Planning Submission – Parramatta Light Rail Stage 2 – SSI 10035

This planning submission has been prepared by Barker Ryan Stewart on behalf of Tanert Pty Ltd who are the owners of existing industrial sites at 2-8 Thackeray Street and 35 Grand Avenue, Camellia.

Transport for NSW has sought planning approval for Stage 2 of the Parramatta Light Rail project under State Significant Infrastructure application SS10035. An assessment of the proposed and alternate alignments for the Camellia precinct has been undertaken by BRS and comments provided under specific headings below. These options are detailed in Figure 1 for reference with our clients sites identified in red.

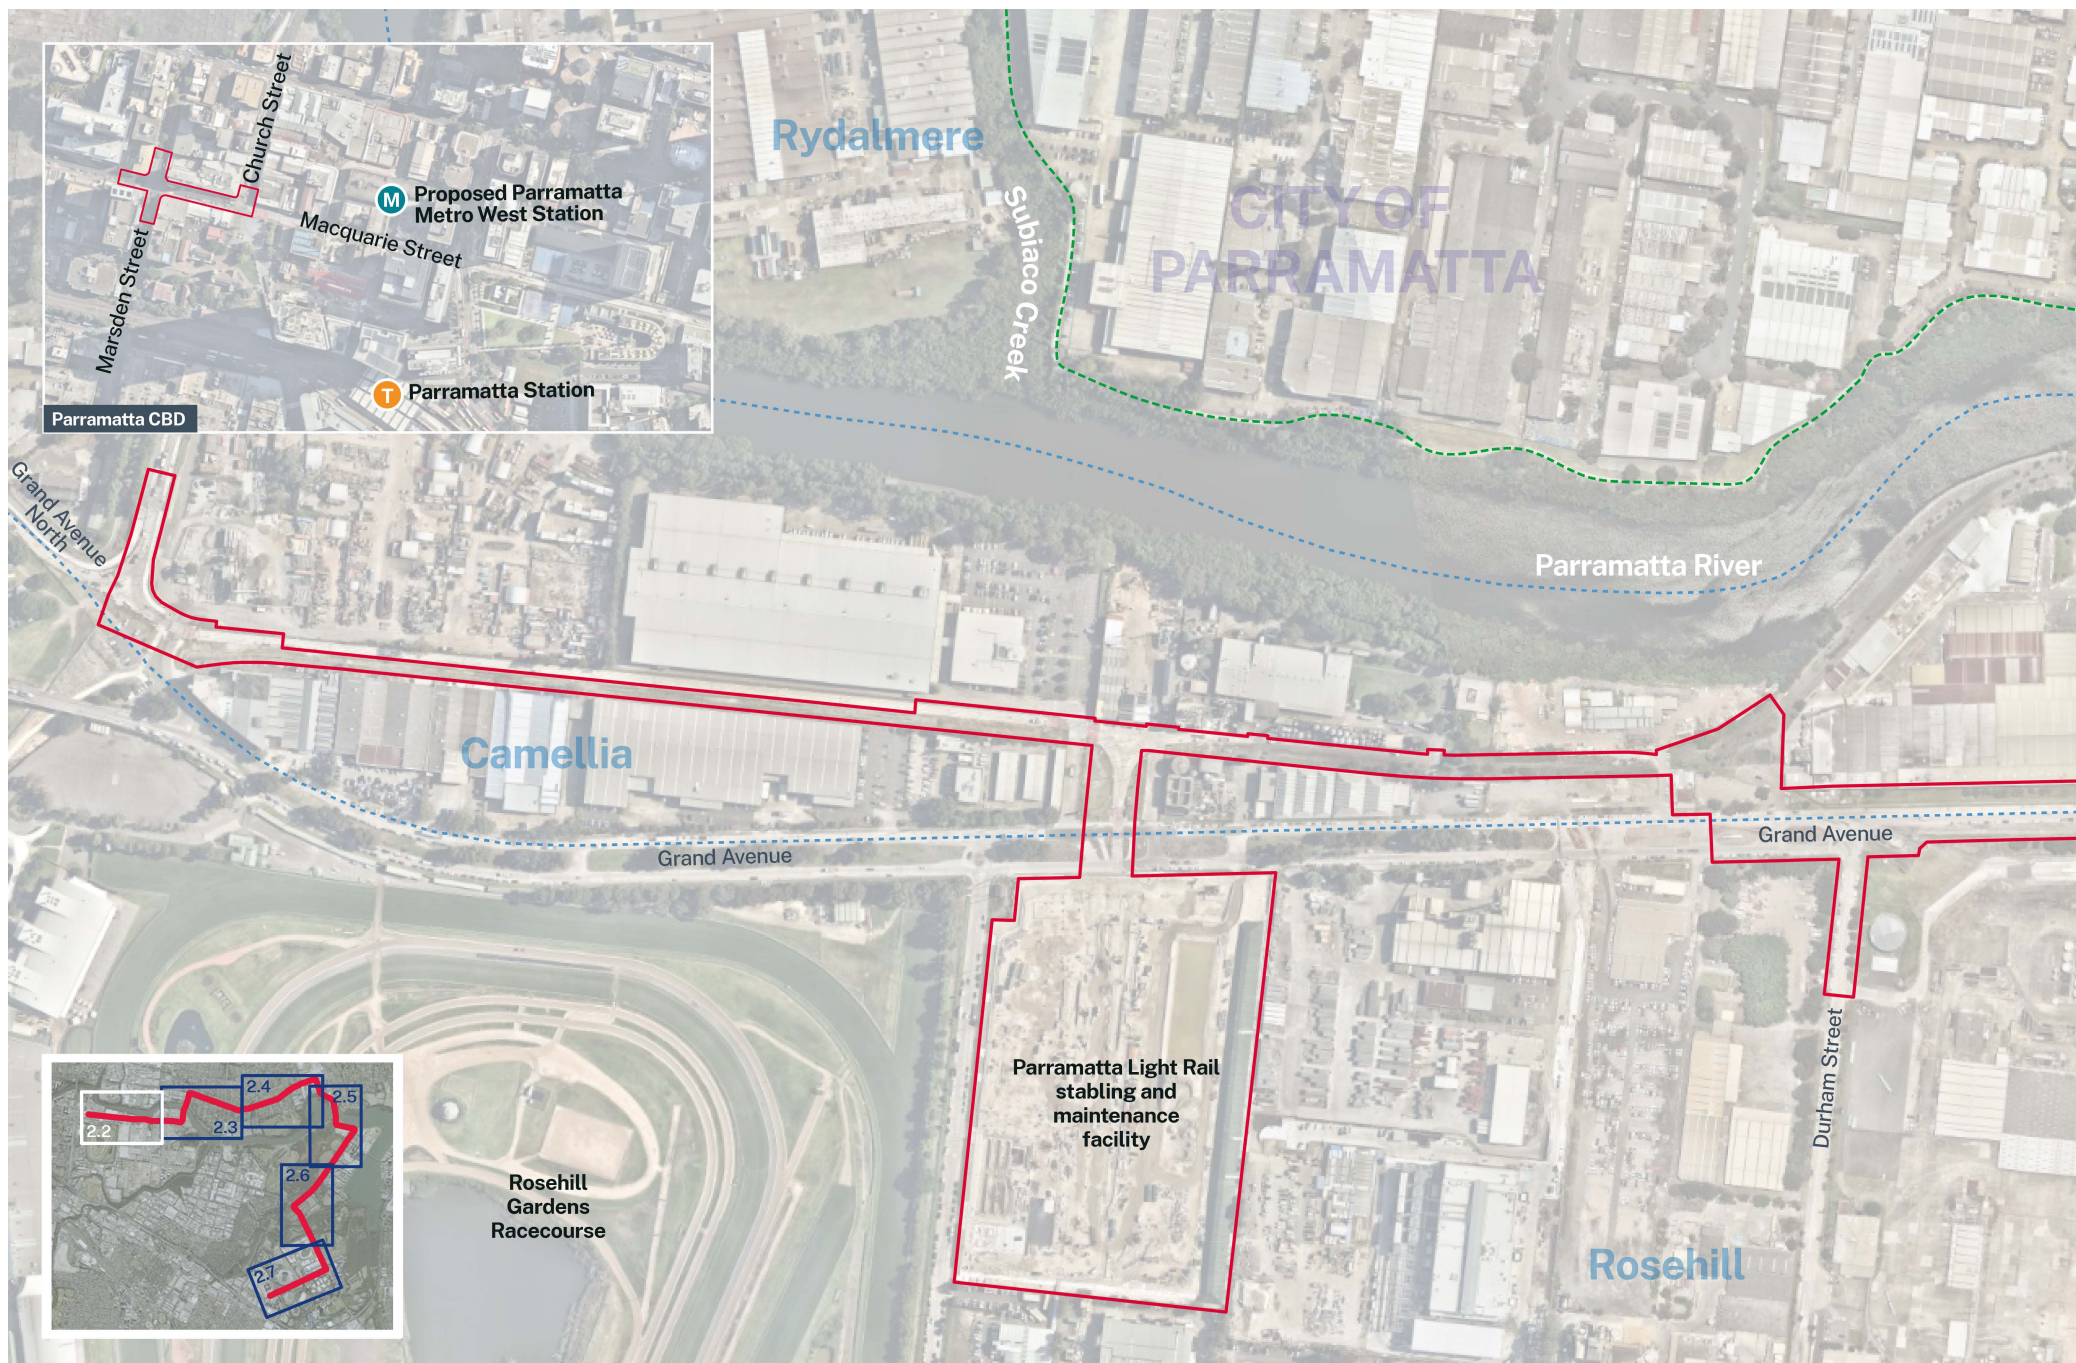
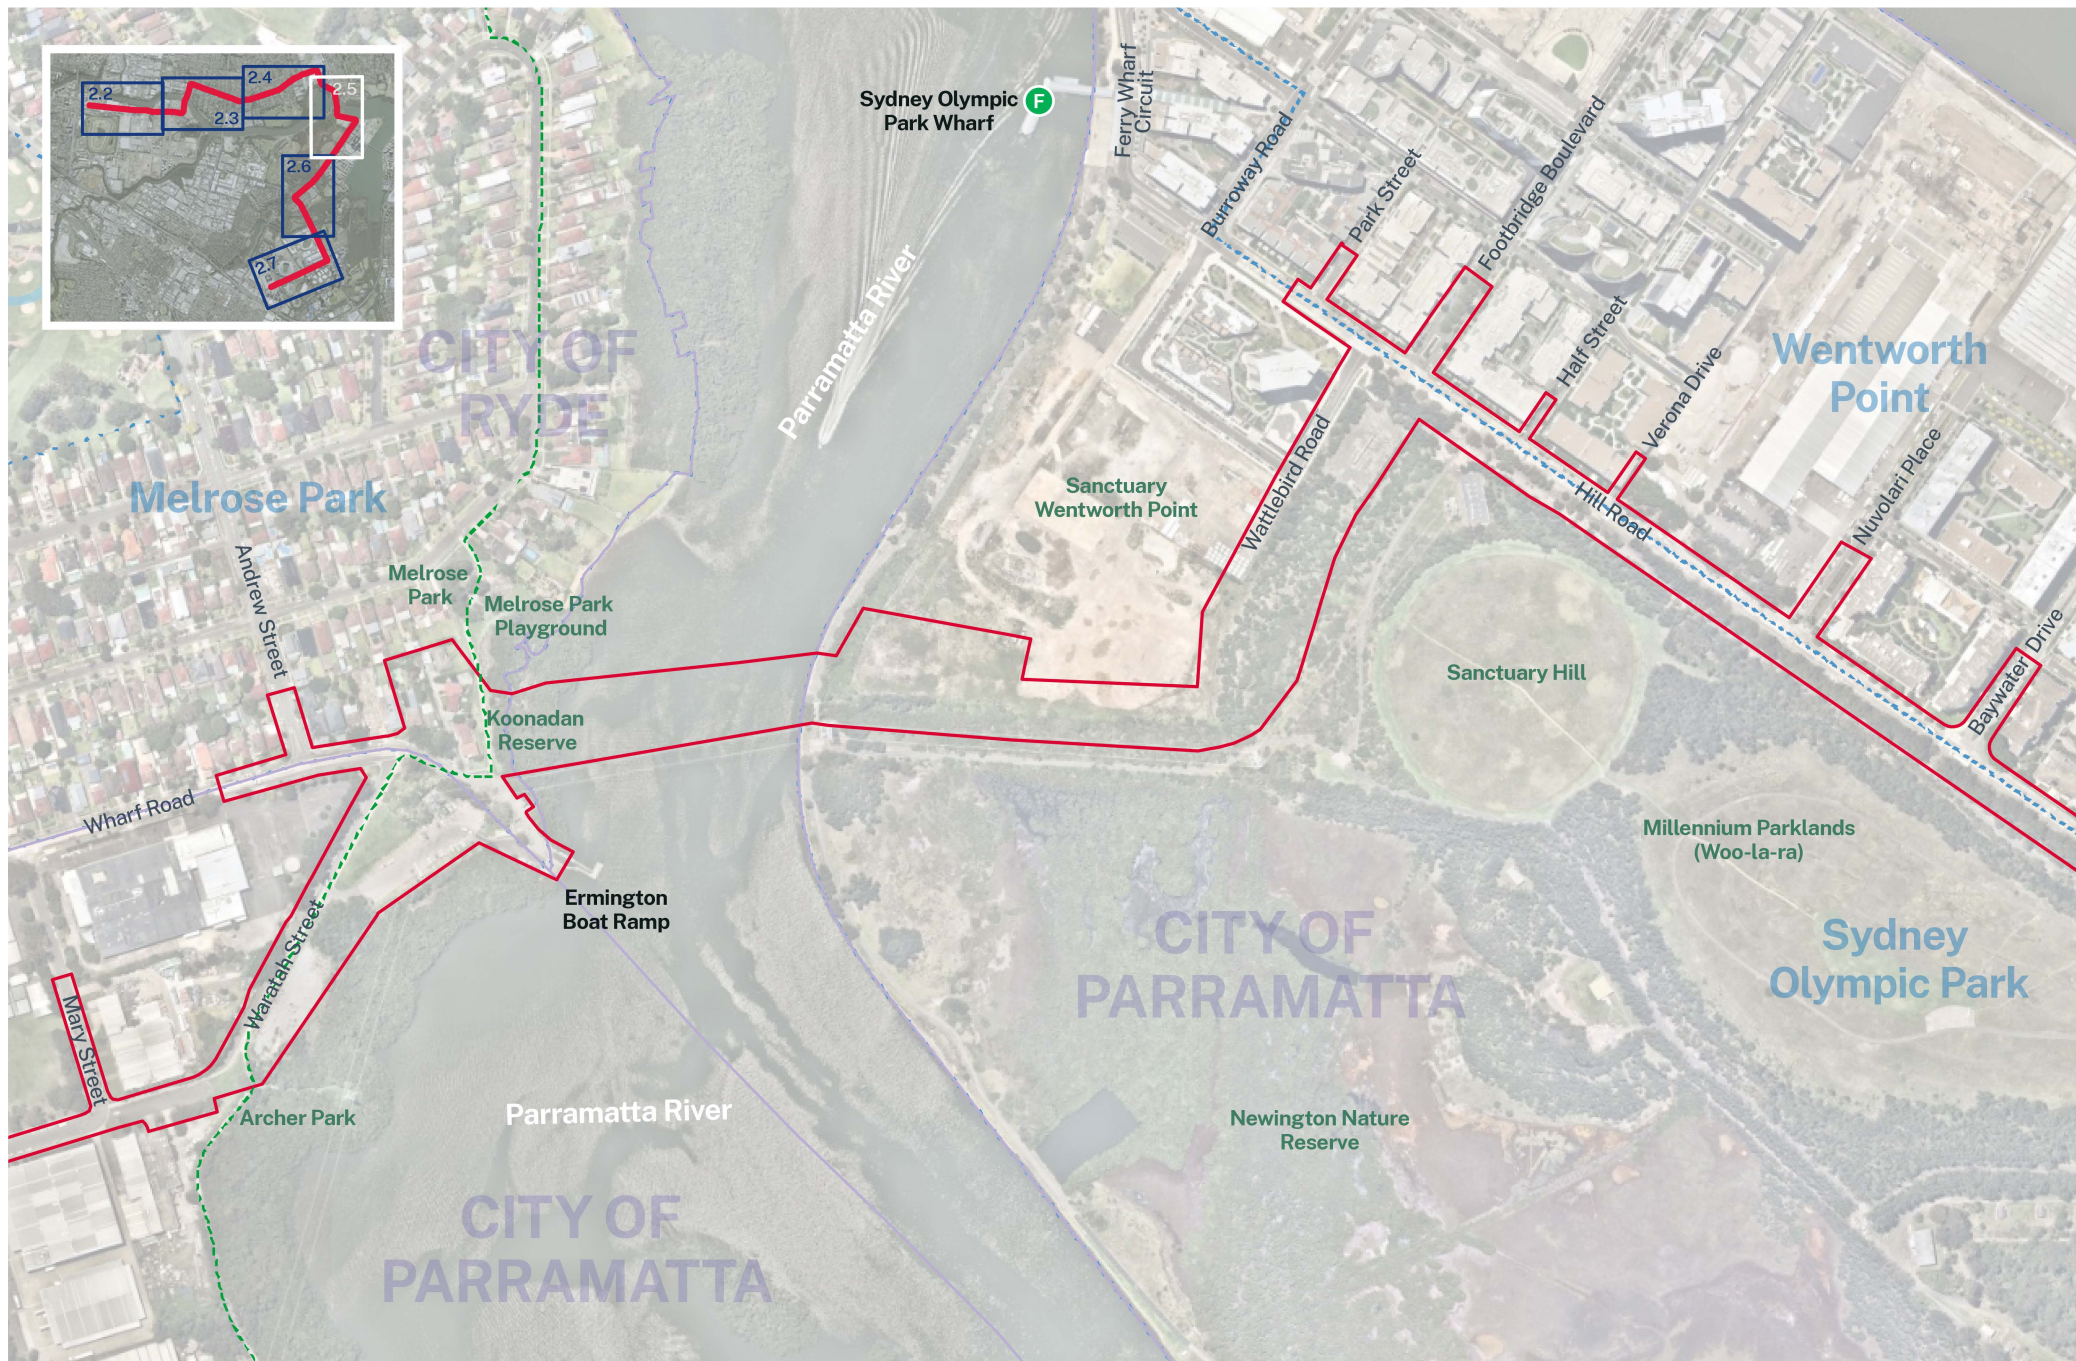
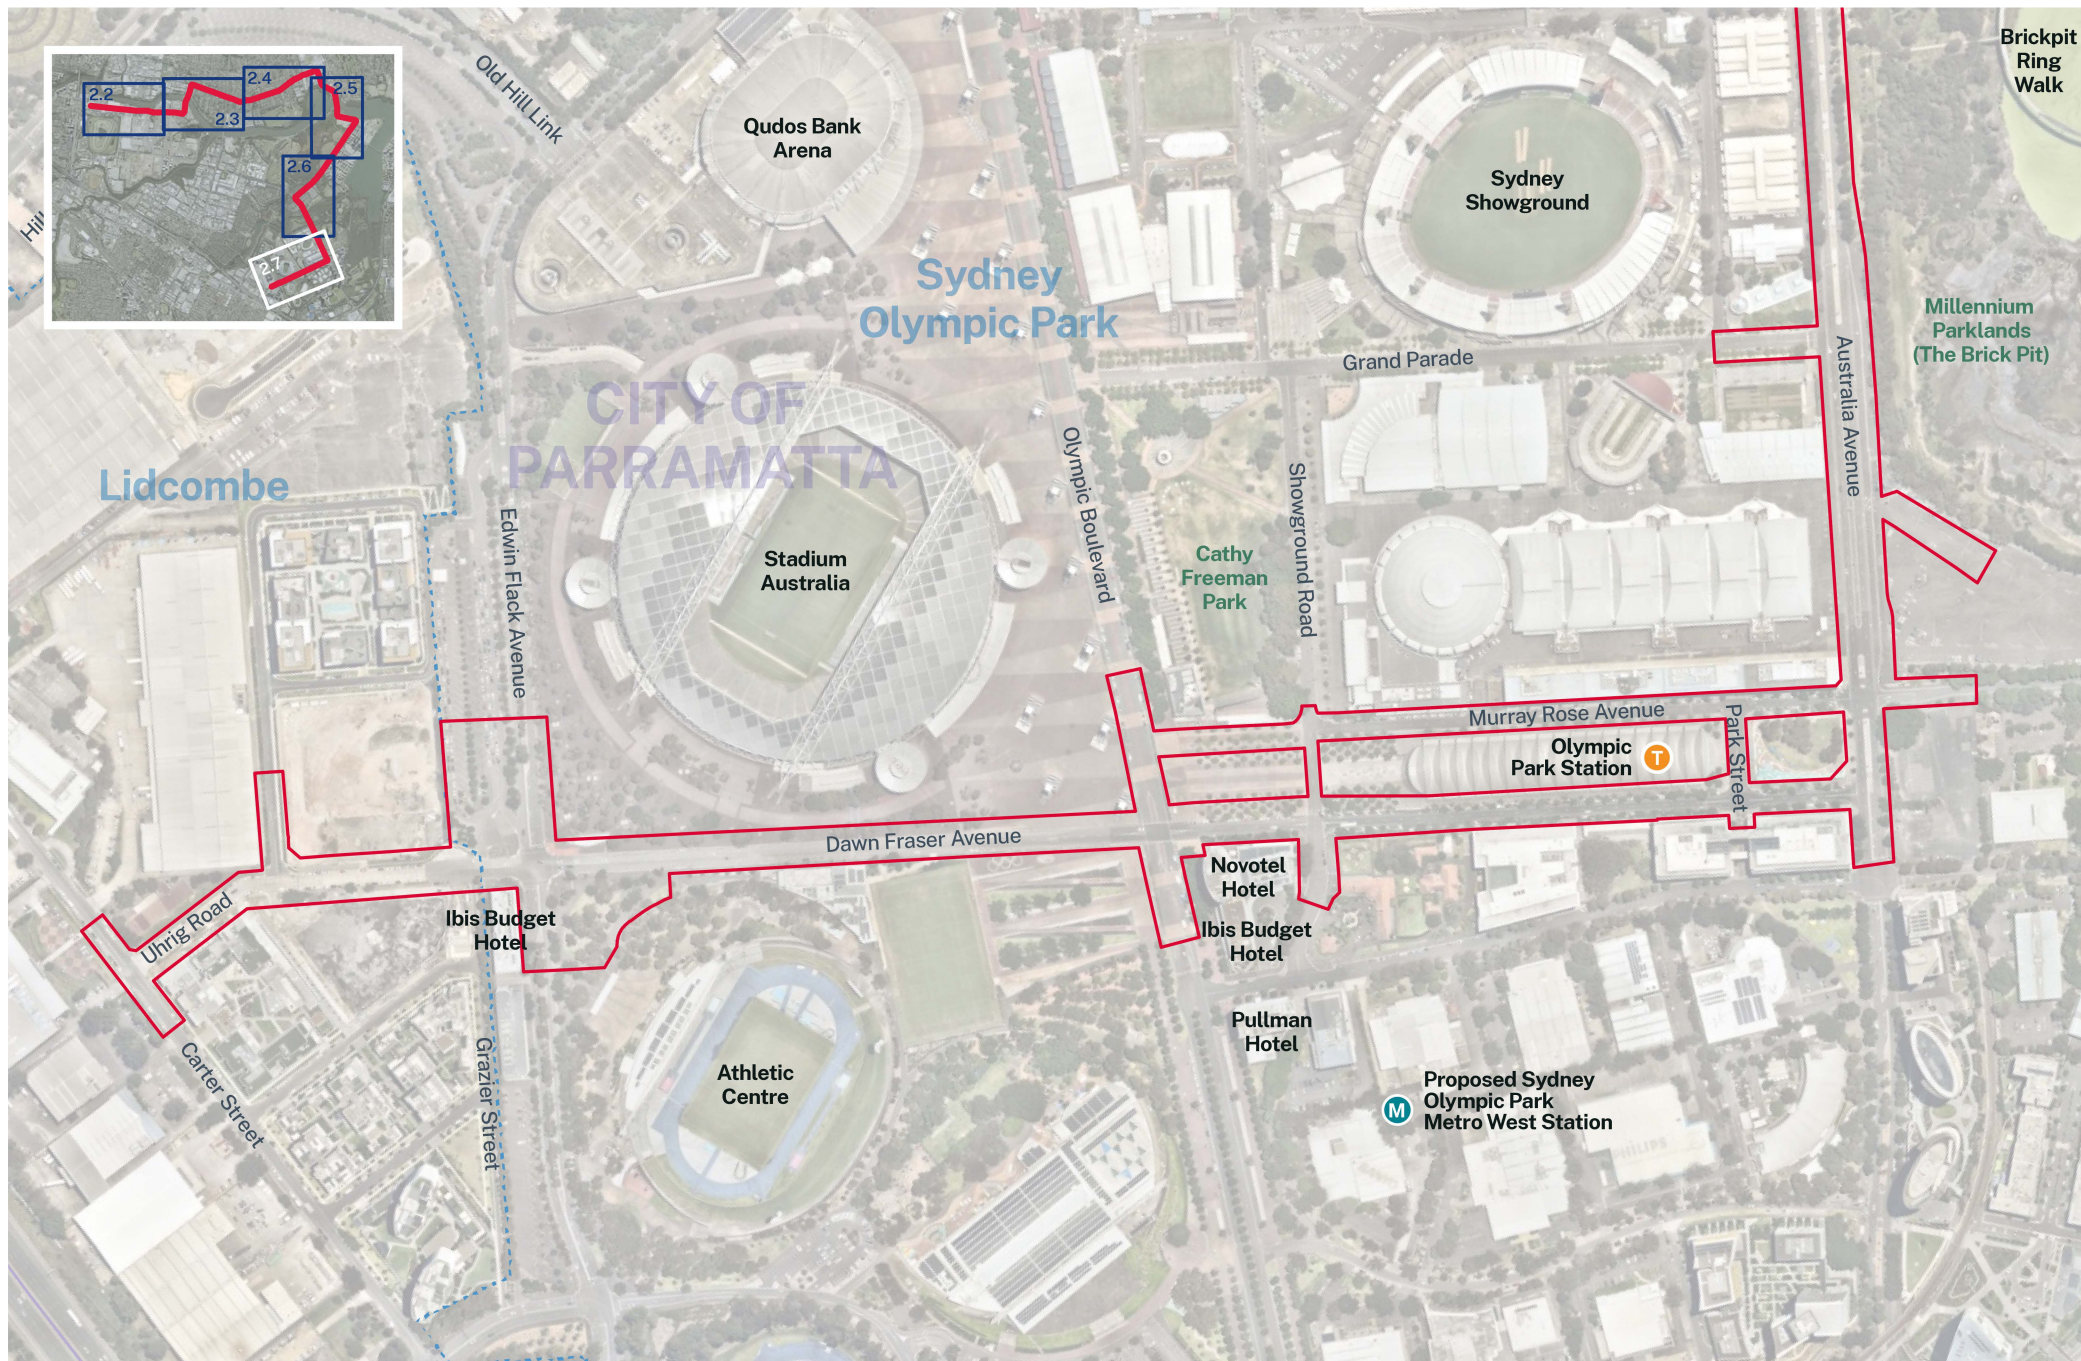
Based on the cross sectional diagram provided in the EIS documentation for Camellia, the light rail will require a 7.4m corridor acquisition from properties on the northern side of Grand Avenue. This acquisition corridor has been indicatively marked in Figure 2 below and within our clients sites, would result in the loss of a modular administration building, egress gate and driveway to Grand Avenue and potential loss or redesign of the hardstand car spaces that are imperative to the operation of the sites. Current tenants, Veolia, have confirmed that partial acquisition impacts will include, but not be limited to, the following:

Whilst our clients aren't predominantly objecting to the proposal on grounds of acquisition, the alternative development route will require less private property acquisition which will result in a reduced impact on the established operation of important industrial sites in the east of Camellia. In our opinion the alternate route represents a more functional and appropriate design response that takes into consideration the level of impact acquisition would generate on Grand Avenue.
